# Sketch Design Disability Access Review

## The Ribbon Grocon Darling Harbor Development

July 3<sup>rd</sup> 2013

# Sketch Design Disability Access Review: The Ribbon Grocon Darling Harbor Development

OFFICE LEVEL 06 PLAN
RL 46.500

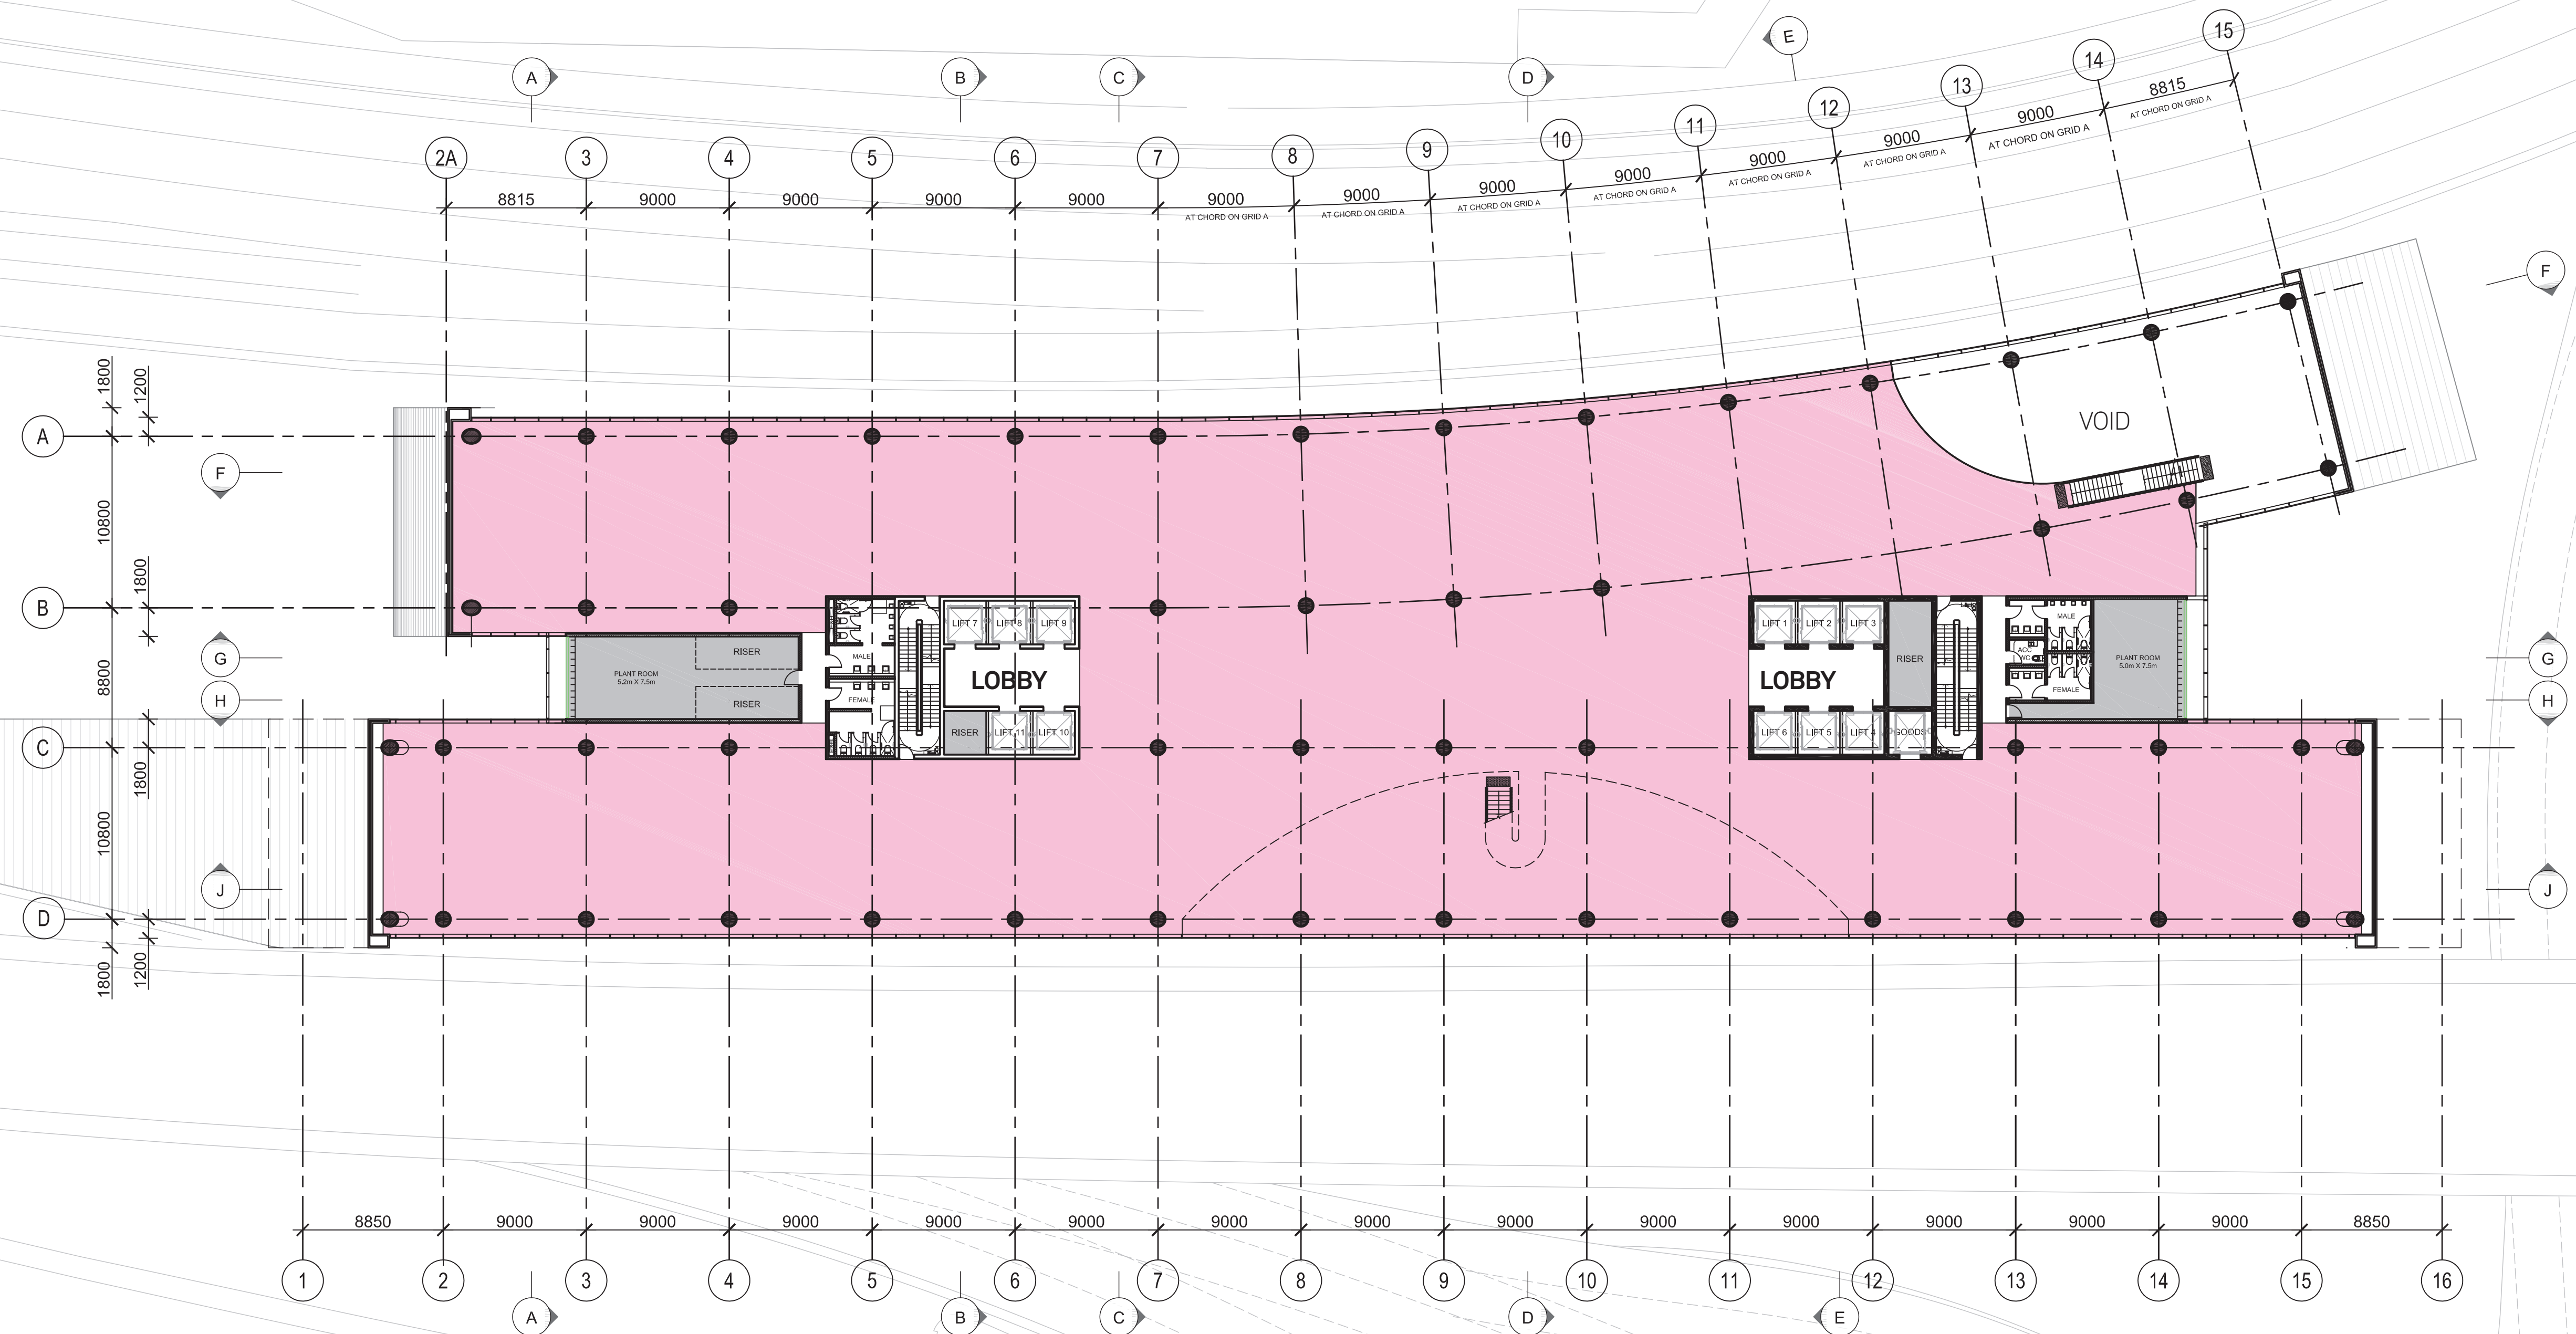
CLASS 5 - Levels 01 – 14 Office Floor Plans and Level 01, 03, 04 Podium Floors		
Lift banks	The west and east wings each have a bank of 6 lifts spanning the office and podium areas. Destination control lifts may leave the building open to a DDA complaint from blind or vision-impaired staff in upper levels as they are difficult for independent operation.	<b>Discuss options with lift providers and ensure some form of equitable use is possible. Whatever type is selected, ensure the lift internal and external controls (if any) comply with AS1735.12 and Table E3.6(b) of the Premises Standard, which specifies the requirement for audible information within all lift cars and other criteria.</b>
Inclined columns	For any spaces that have the structural inclined columns, some form of warning will be required	<b>Plan for protection up to a vertical clearance height of 2m for inclined columns in upper storeys, including the application of</b>

to a vertical height of 2m.	<b>contrasting TGSi. Discreet TGSi must contrast by 45% to the floor material selected.</b>
Structural column contrast	The open office floor plates with columns in regular grids, largely hidden by walls meets the requirement for access in any configuration of voids.	<b>All columns that remain visible must have 30% luminance contrast to floor surface material.</b>
Function Balcony	Issues of water barriers at the external balcony to the internal floor can make access barriers with lips and vertical gaps.	<b>Ensure a tested design solution is used on any outdoor transitions to internal surfaces that avoid lips of over 5mm.</b>
Podium Level 01	No shower shown in accessible toilet on Level 01 – cyclist shower.	<b>Document accessible shower and associated elements in Level 01 unisex toilet and check whether lockers are best placed in this room.</b>
Podium Level 04 amenities	If this tenancy is fitted out as a gym, it will need a shower in the accessible toilet.	<b>Provide a unisex accessible a toilet/shower for the gym on Podium Level 04.</b>

Accessible toilets in upper storeys	The unisex accessible toilets shown in the east wing office and Podium levels are all right hand transfer.	<b>Mirror the toilet design for right and left alternation to access toilets to create facilities with both right and left-handedness.</b>
Ambulant cubicles	Each of the toilet bank designs provides for a cubicle to suit people with ambulant disabilities.	Provision complies with the Premises Standard. Note grabrail length can be shorter than shown – they do not need to be full length. <b>See AS1428.1 Figures 53(A) and (B).</b>
West Wing accessible toilets Office Levels 01-09	Table F2.4(a) minimum requirements for Class 5,6,7 and 9 buildings calls for 1 accessible toilet on each storey where there are other toilet banks and where a storey has more than 1 bank of male and female toilets, another toilet on not less than 50% of those banks.	<b>Provide a unisex accessible toilet in the west toilet bank of every floor to ensure equity if tenancies are divided or for employees working in the western wing and make the building easier to construct with a consistent plan on each level. Ensure that the toilet complements the handedness of the other access toilet on that storey.</b>
